Attachment K – Detailed Response to Submissions Table

Attachment K – The Children’s Hospital at Westmead - Multi-storey Carpark (SSD-10434896) – Detailed Response to Submissions Table

Typical Floor Plan

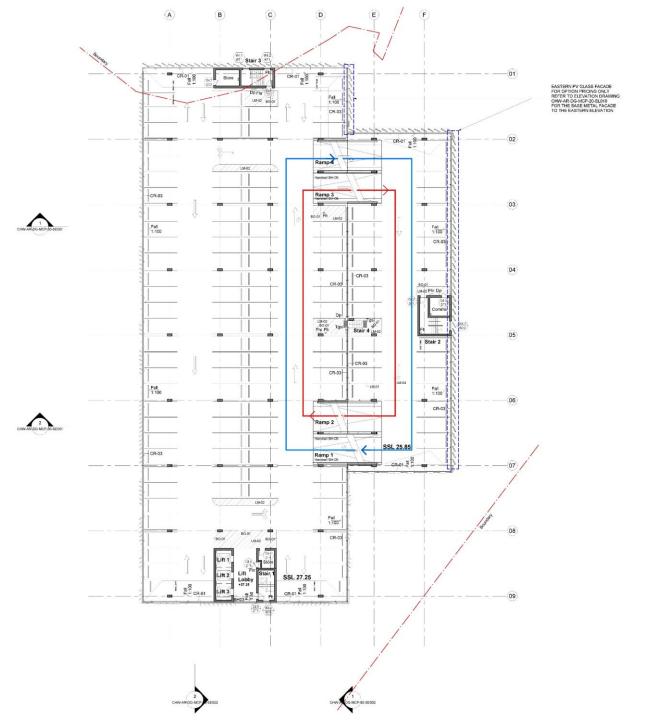
18	<p>Traffic and Transport</p> <p><i>The dimensions of the parking spaces and aisle width as shown in the submitted architectural plans are 2.6m wide and 5.4m long for normal car spaces except for</i></p>	<p>The proposed car parking design has been revised to comply with AS2890 with provision of car spaces at 2.6m by 5.4m and small car spaces at 2.3m by 5.0m.</p>

<i>the ones along the fencing in Level P1 where they are 2.6m wide and approx. 5.1m long. Dimensions for small cars are 2.3m wide and 5.4m long and accessible car spaces are 2.4m wide and 5.4m long. The length of the car spaces along the fencing in Level P1 will need to be lengthened to at least 5.4m to comply with Australian Standards. Motorcycle parking dimensions are 1.2m wide and 2.5m long and aisle widths are at least 5.8m wide which is considered acceptable.</i>	Refer to the updated Architectural Plans prepared by Billard Leece Partnership Architects at Attachment A .
19	Traffic and Transport <i>The car park design including aisle widths, column locations, swept paths and sight lines are to comply with AS2890.1</i>	The proposed development complies with AS2890.1. Refer to the Revised Transport Assessment at Attachment G and Architectural Statement at Attachment C .
20	Traffic and Transport <i>Swept path for a 6.4m service truck indicates that several spaces would need to be unoccupied in order to park/exit the designated car space. Additionally, the truck is required to park in two car spaces which means the adjacent car space will also need to be kept unoccupied. It is unclear how these spaces will be managed and kept unoccupied to allow the service truck to access/exit the spot.</i>	These spaces would be maintained for substation access. Substation access would be in a managed scenario only (would likely require entry ramp to be partially or fully closed, and managed such that it occurs outside of peak times). It is not anticipated multiple vehicles would require this area at the same time.

<b>Noise Model</b> Construction Noise Modelling Results Noise & Vibration
1:200 SCALE @ A0	44311 PROJECT NO	MSCP-AC-GRM 001 DRAWING NO REV

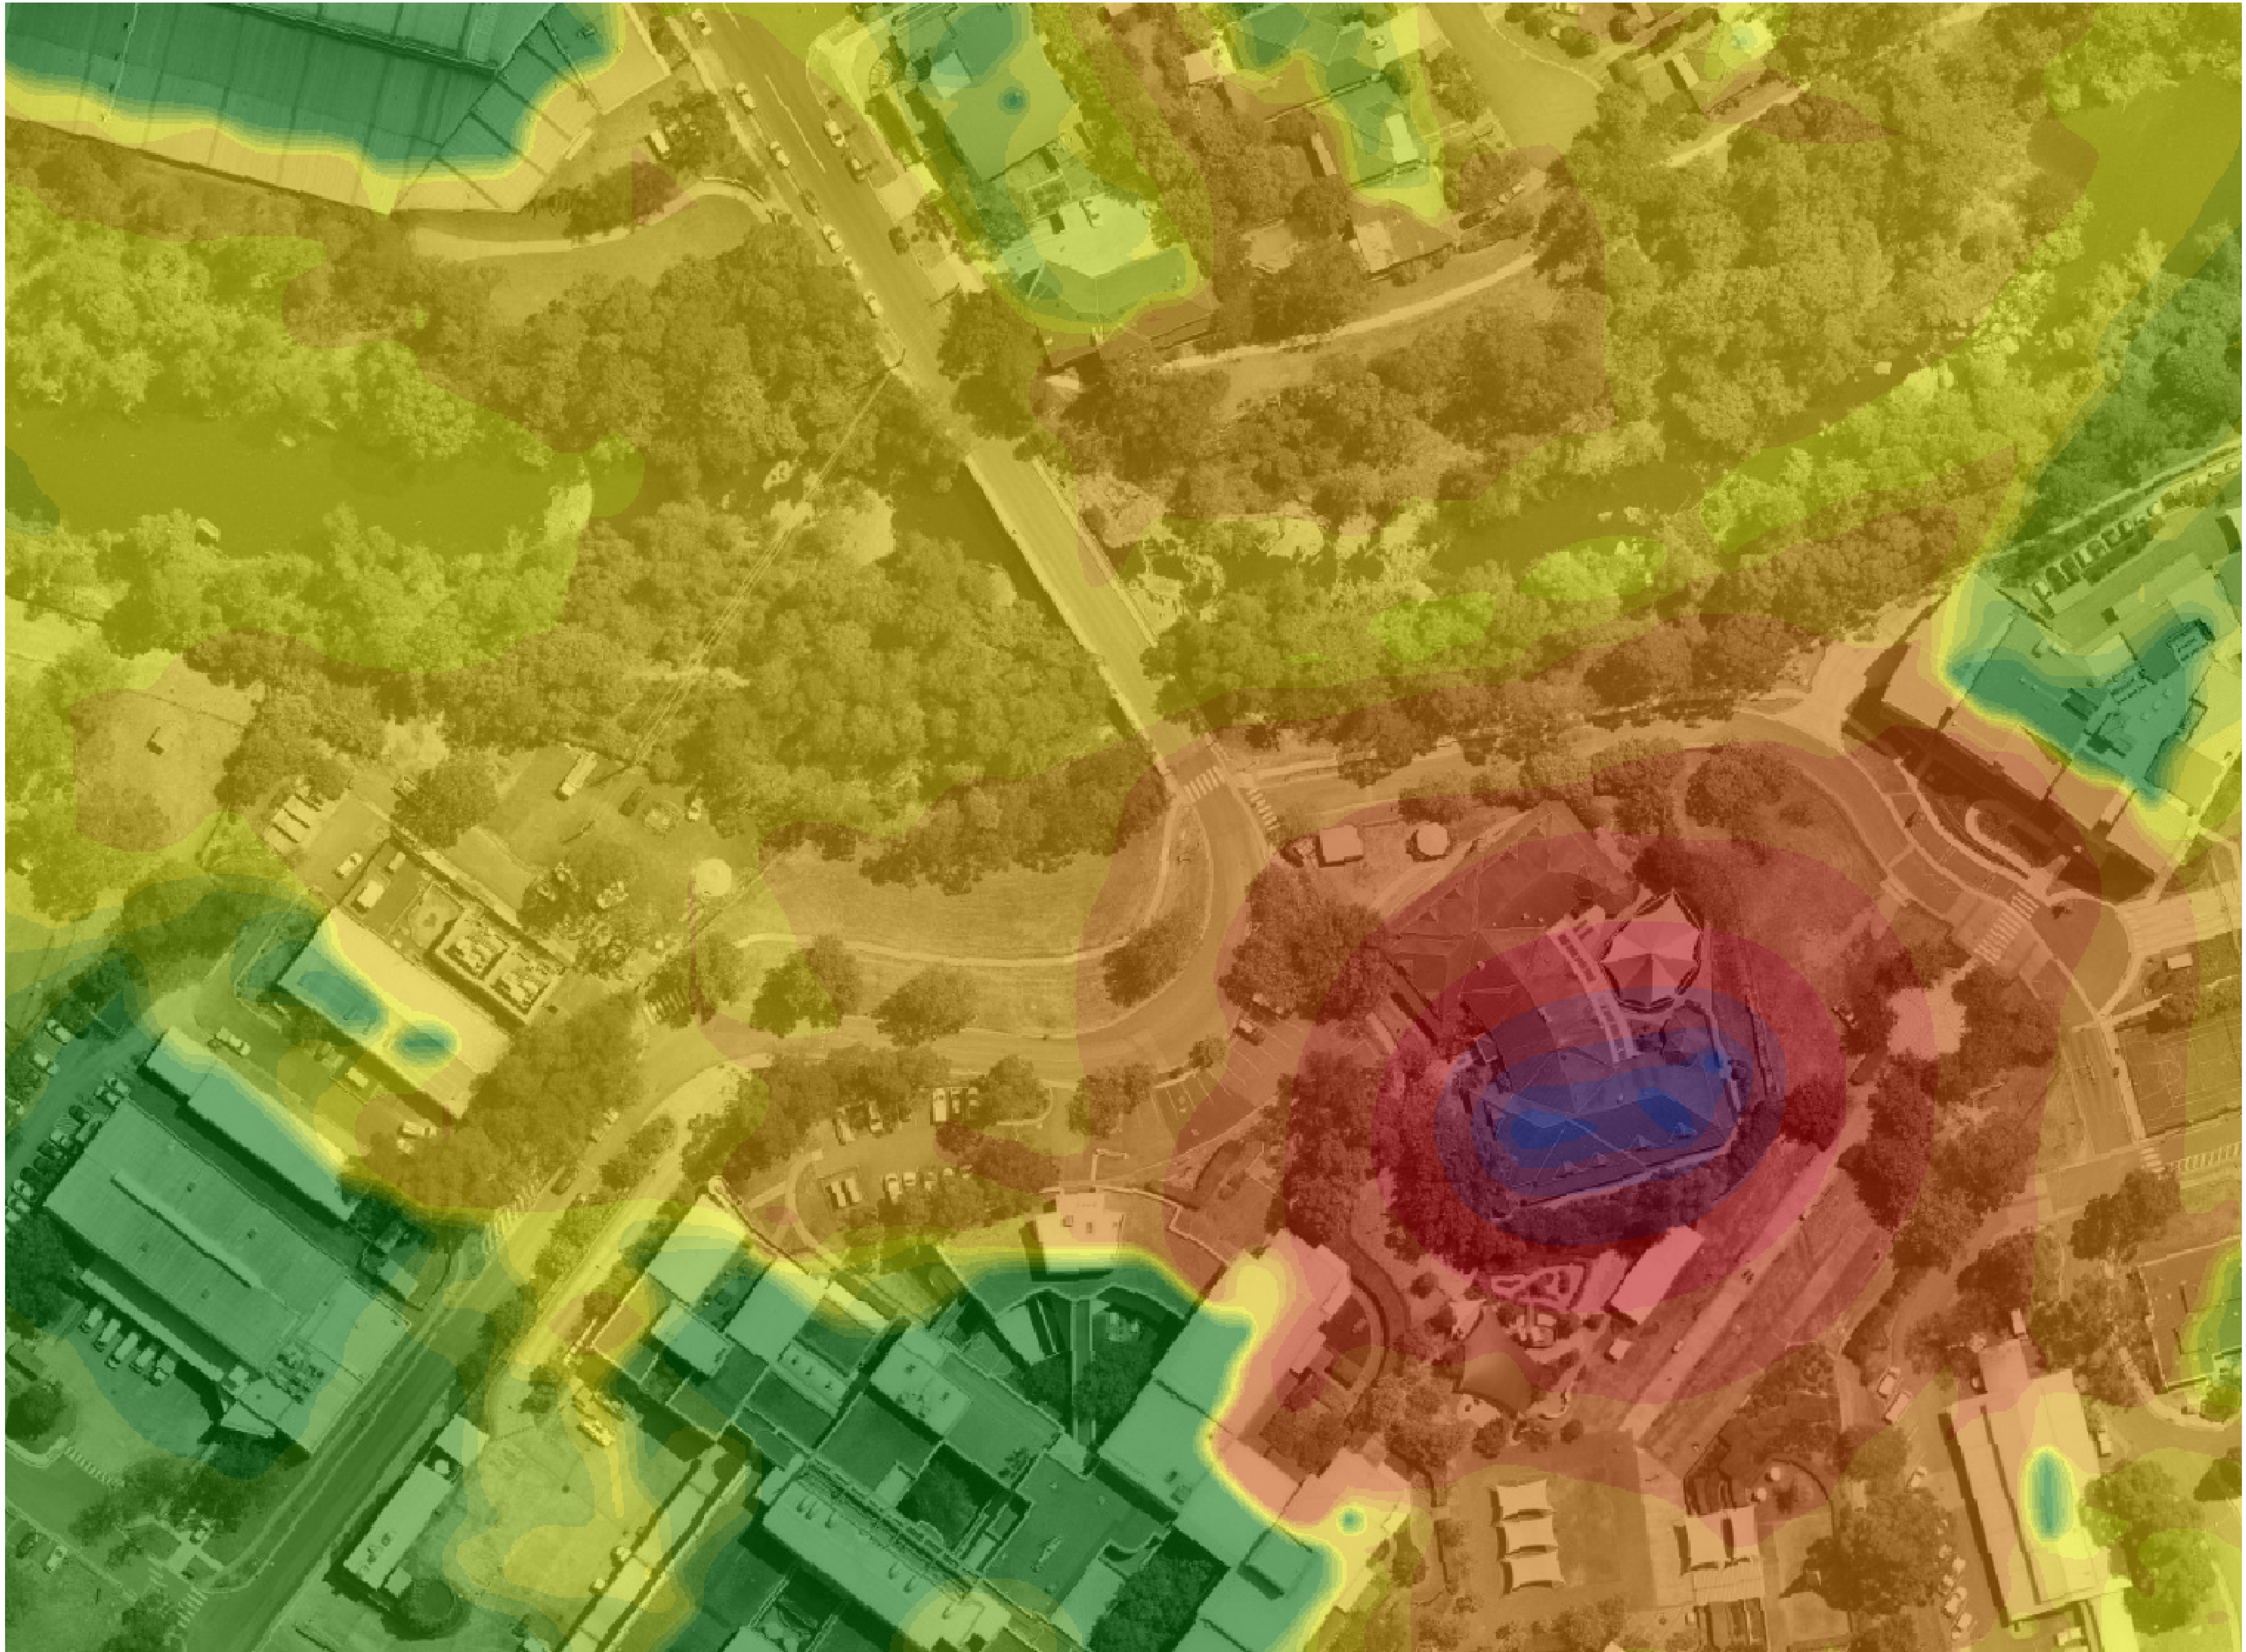
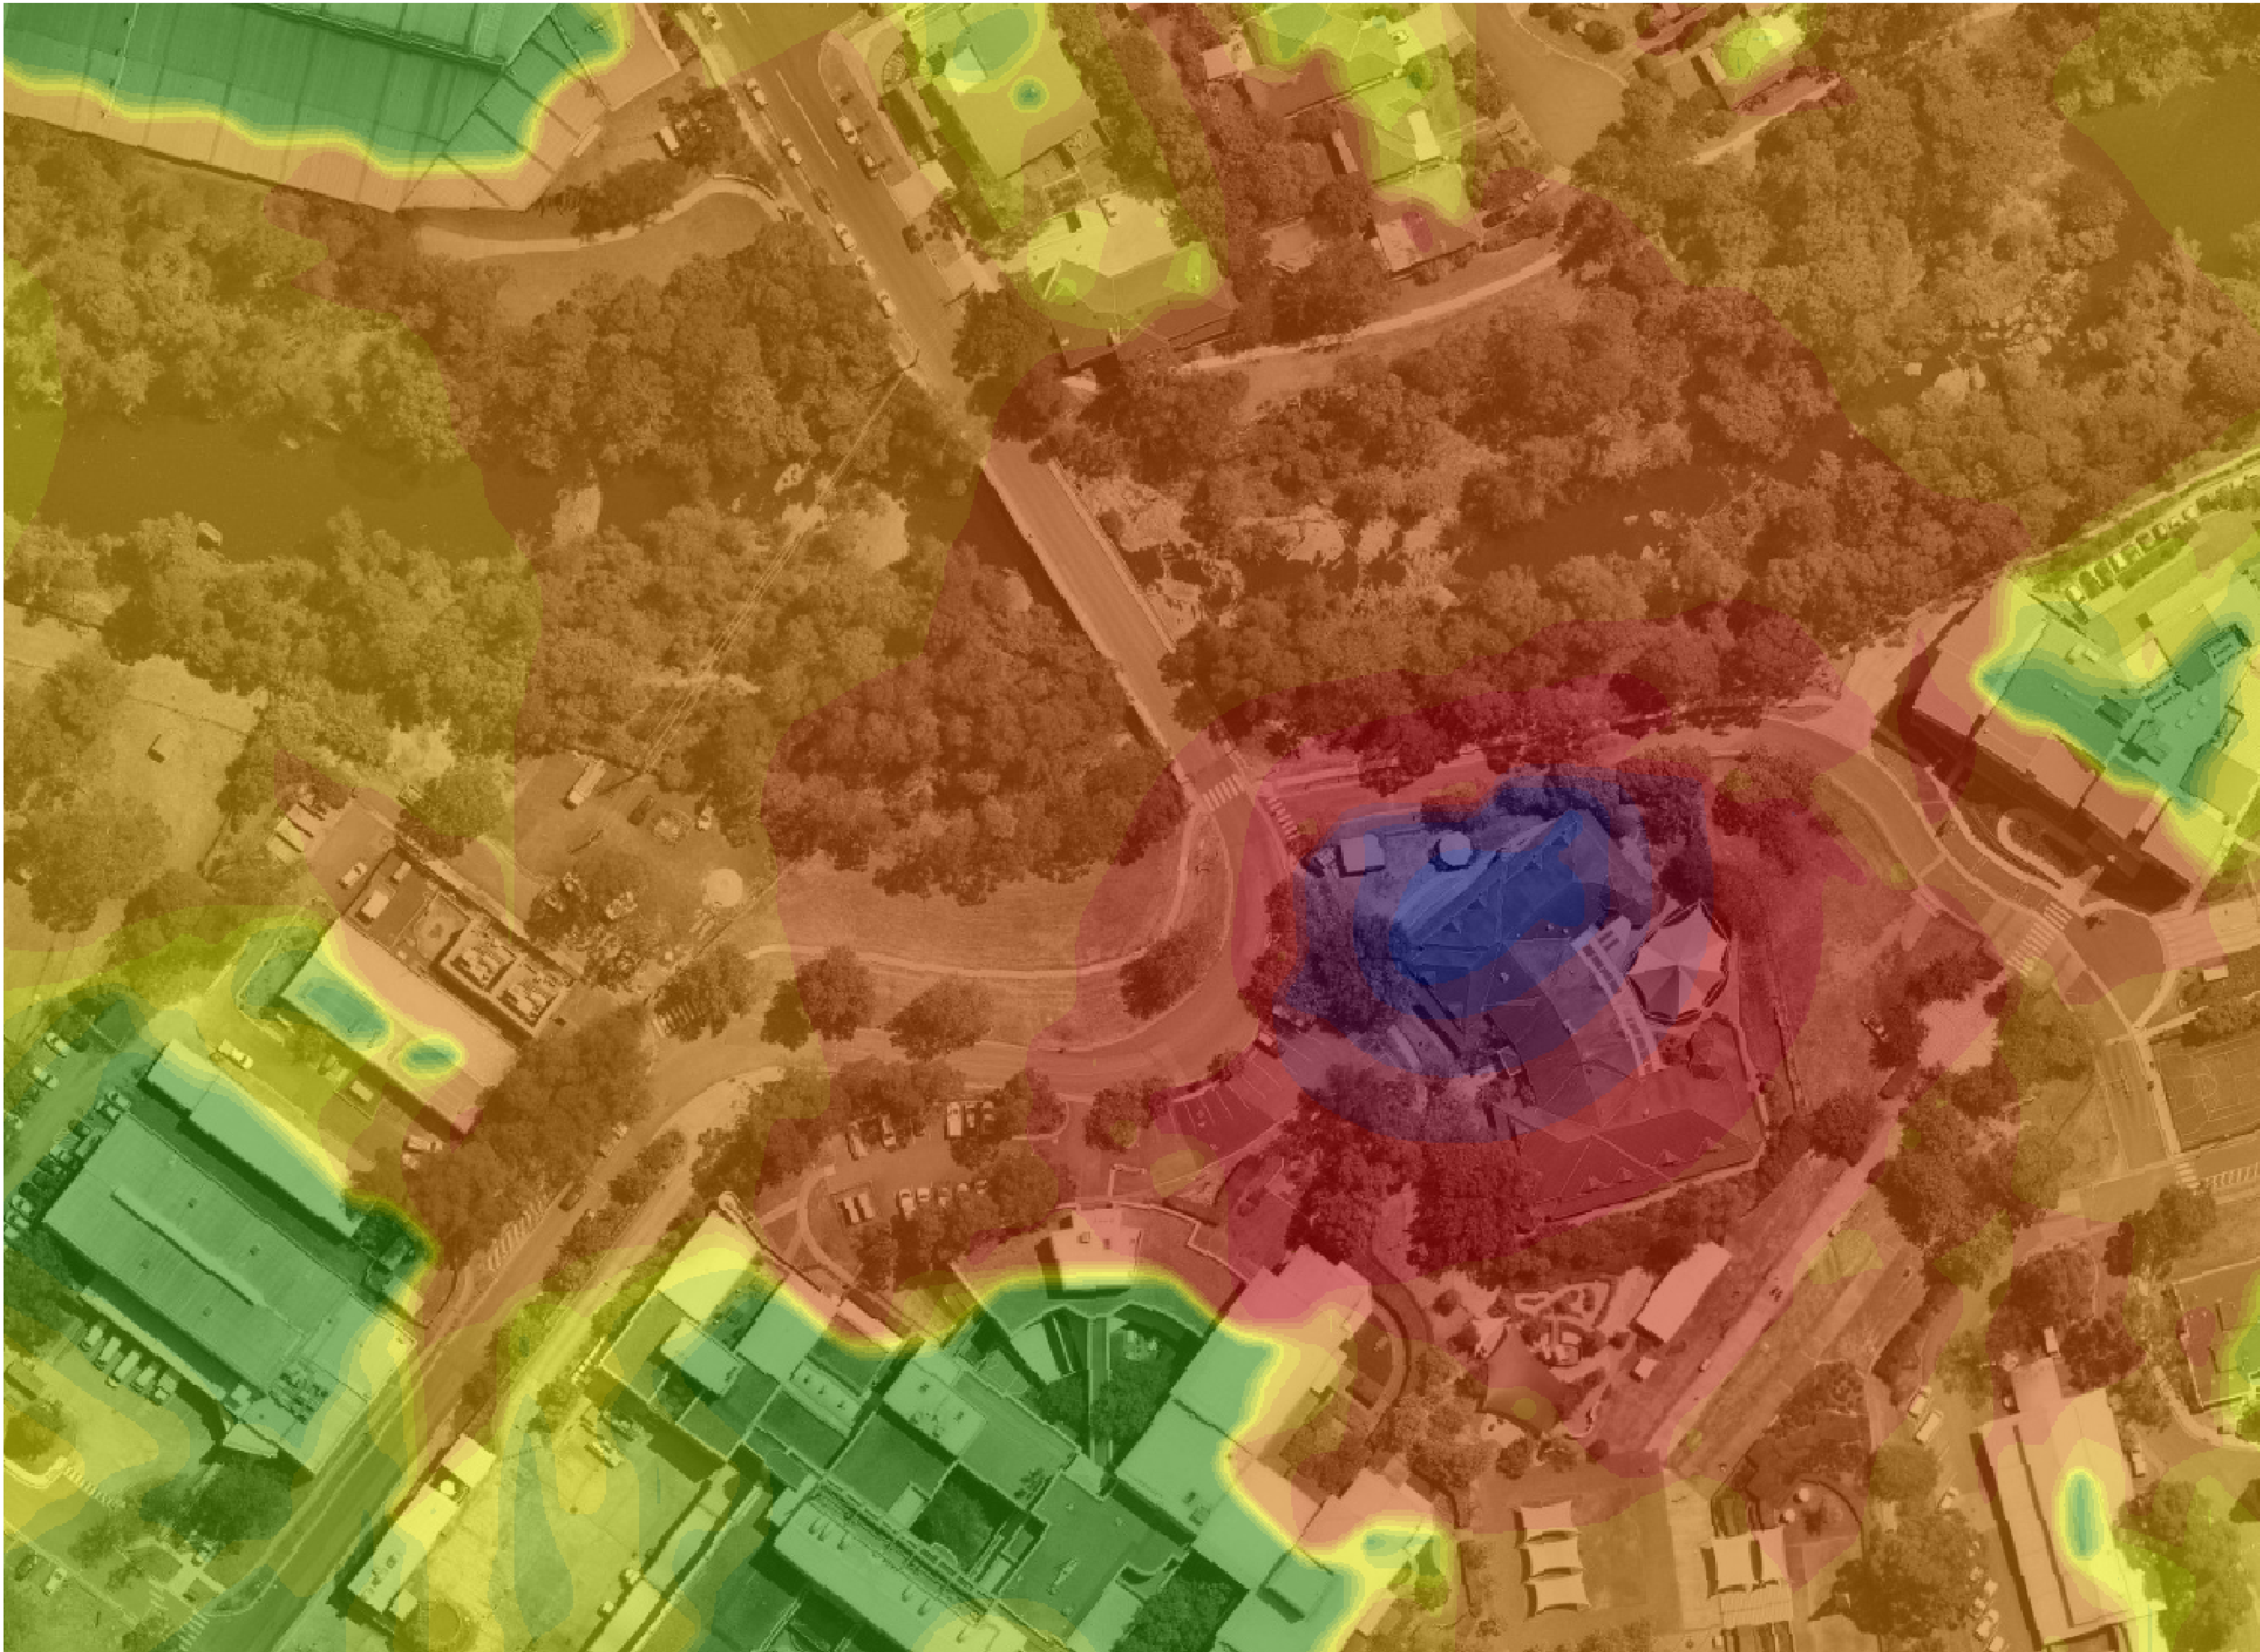
Row	Issue raised	Proponent’s response
Department of Planning, Industry and Environment		
1	<p>Acoustic Impacts</p> <p><i>Cumulative construction noise impacts associated with surrounding concurrent developments are to be provided (particularly the Paediatric Services Building Redevelopment).</i></p>	<p>The construction program indicates the following timing for construction:</p> <ul style="list-style-type: none"> • The MSCP construction will be occurring for the duration of the Paediatric Services Building (PSB) construction; • The structure and façade work for the MSCP are proposed to occur from July 2022 to March 2023; and • The PSB (subject of a separate planning approval) inground works will take place approximately from January 2022 to July 2022. The upper structure will commence from July 2022 to Feb 2024. The PSB construction, commissioning and handover is not until Q1 2025. <p>Given that the MSCP and PSB (subject of a separate planning approval) are 250m apart, and buildings that separate them provide acoustic shielding between the two sites, the cumulative noise impact during simultaneous construction is concluded as negligible. During a worst-case scenario without the implementation of mitigation measures, the PSB construction noise would be less than 30 dB(A) at the site of the MSCP, and would therefore, not contribute to the noise level at receivers adjacent to the MSCP.</p> <p>For further information refer to updated Acoustics Report, prepared by Stantec at Attachment H.</p>
